Rezoning Transportation Analysis

Petition Number: 2022-224

Date	Description
4-26-23	First Review (IW)
11-27-23	Second Review (ME)

RZ-1

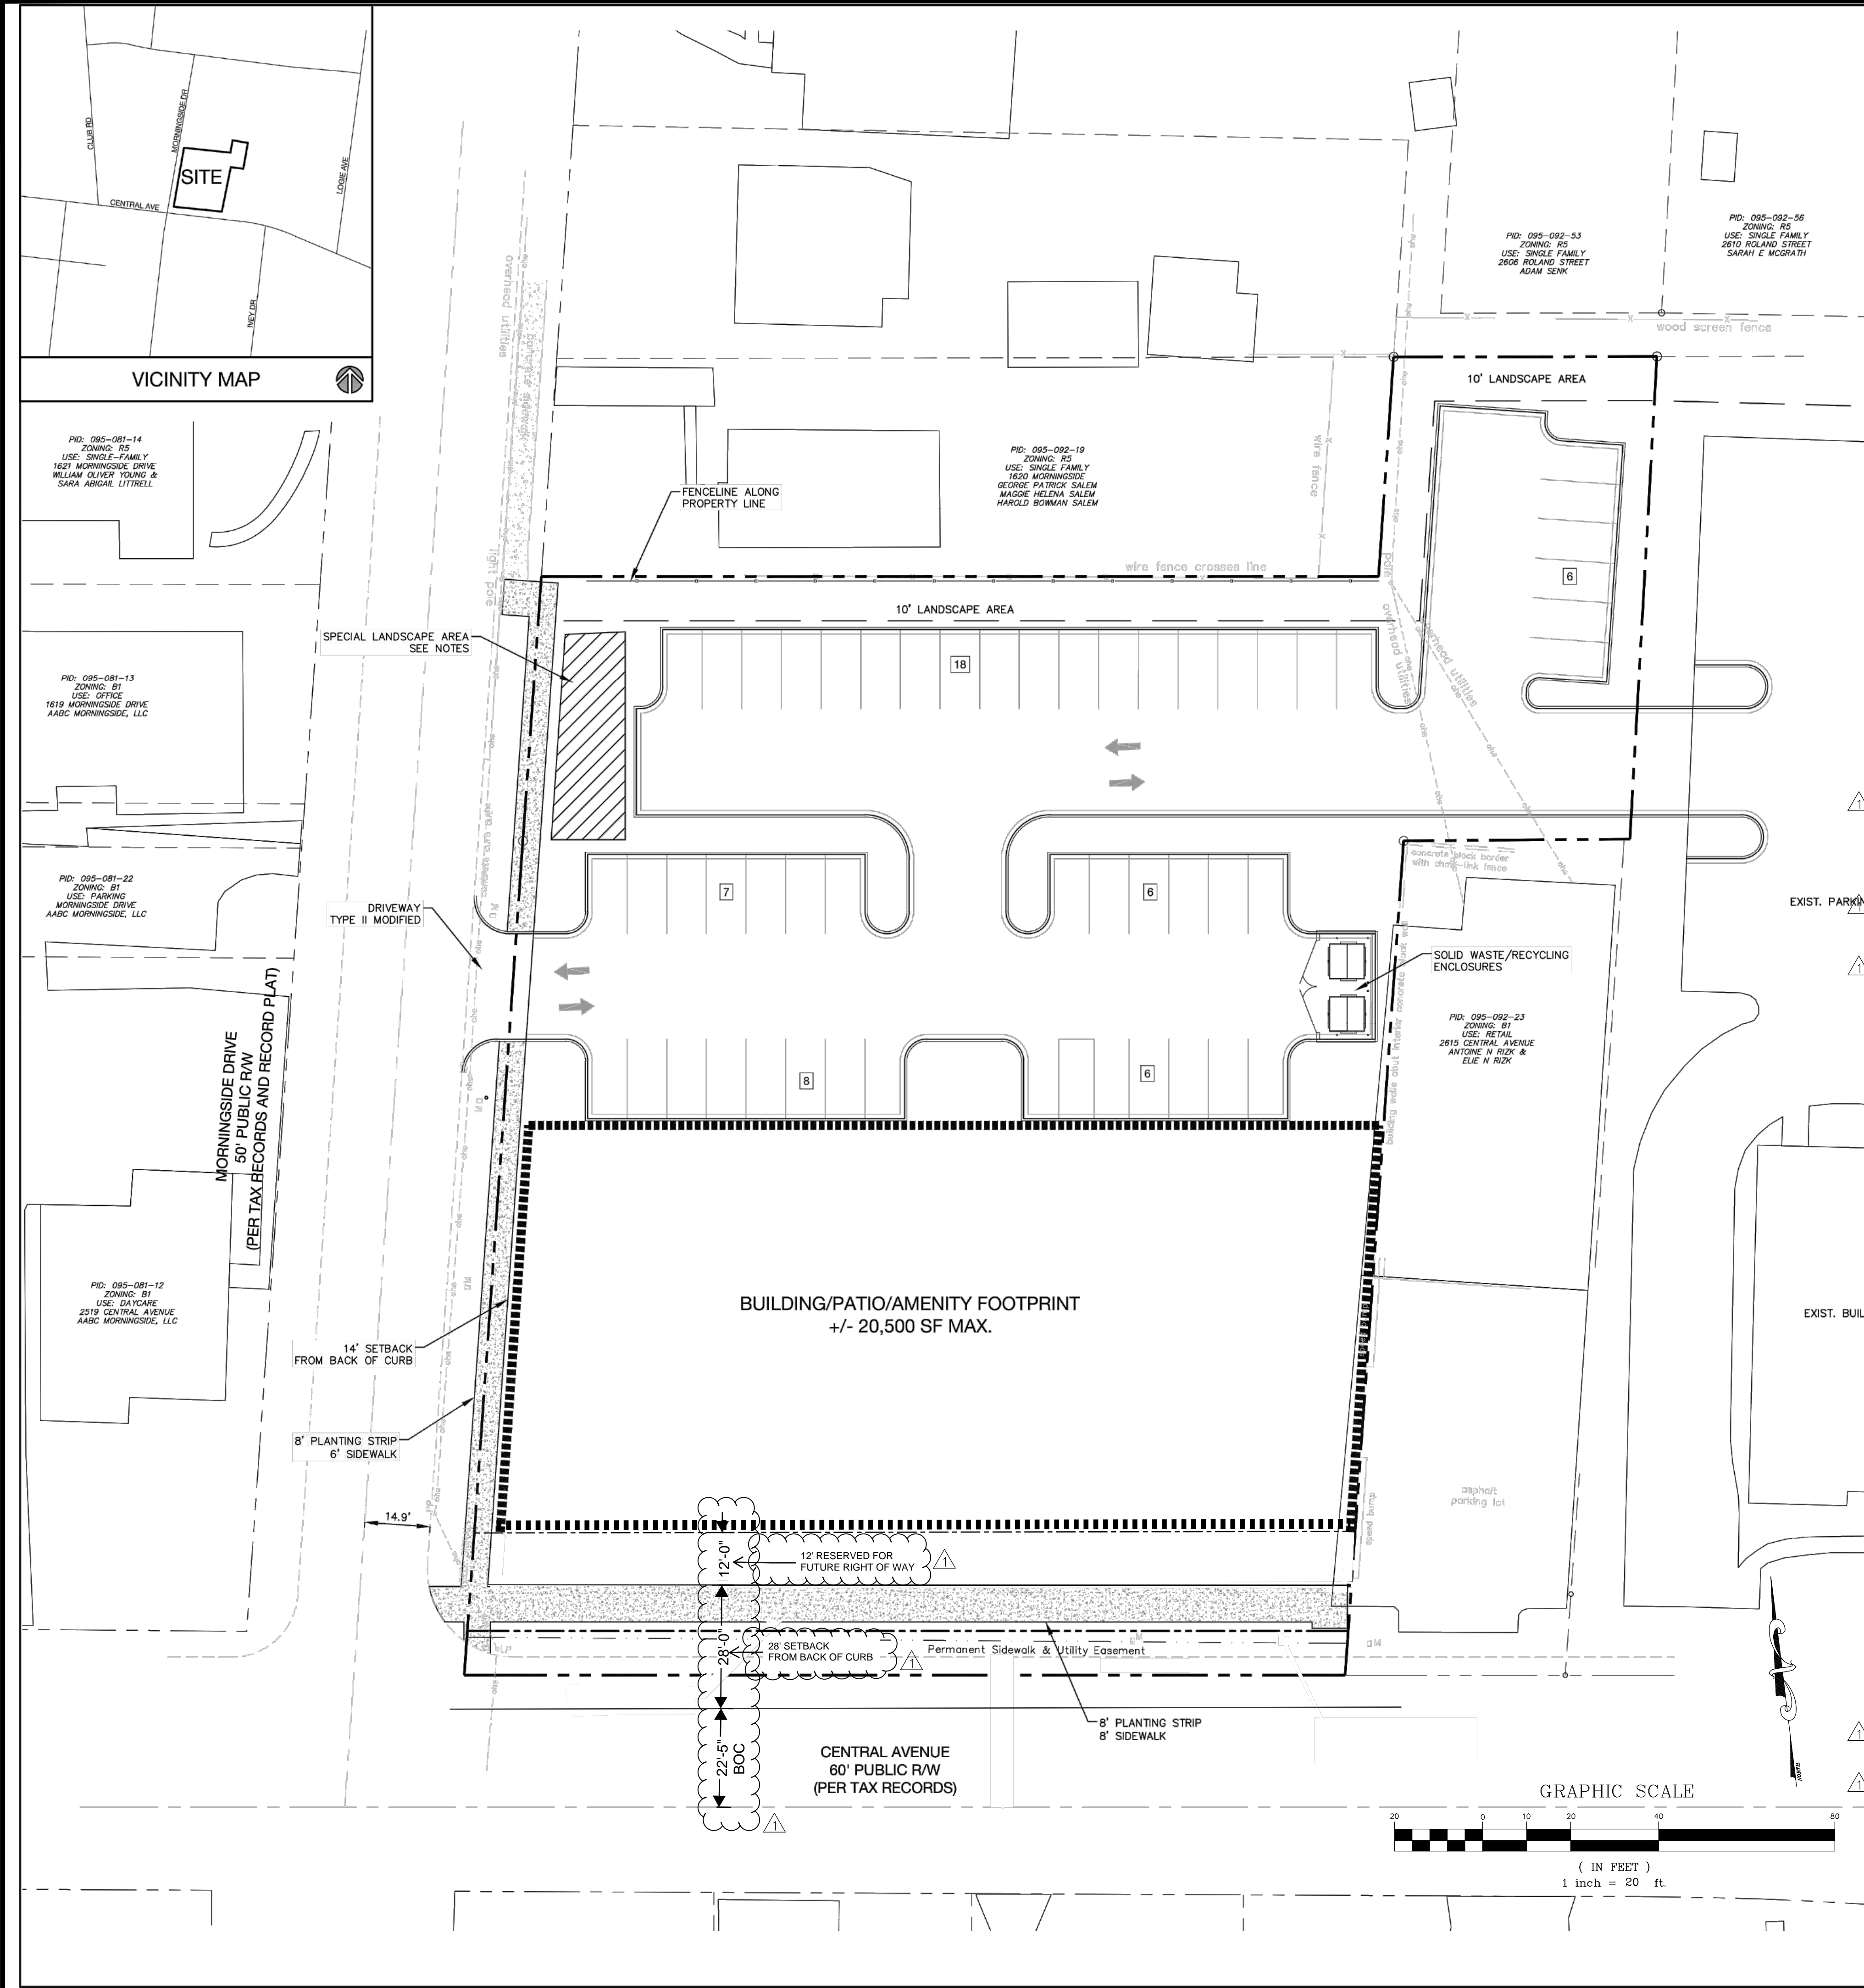
1. Curblines:

- a. **Central Avenue:** Location of curb and gutter to be moved to 32.5 feet from roadway centerline to accommodate the Charlotte Streets Map with a roadway typical section of 4 Avenue with Buffered/Separated Bike Lanes.
- b. **Morningside Drive:** The future location of curb and gutter is in its existing location.

Label and dimension the curb and gutter from the centerline for each road on the site plan.

Comment 11-27-23: Label and dimension curb and gutter locations not shown on site plan. Please add to the site plan.

3. Revise site plan and conditional note(s) to commit to dedicate 50.5 feet of right-of-way from the Central Avenue road centerline. The site plan shall label and dimension the right-of-way from the road centerline.

Comment 11-27-23: Please add a label and dimension showing right-of-way dimension mentioned above on site plan and revise conditional note(s) to commit to previously mentioned right-of-way dimension.
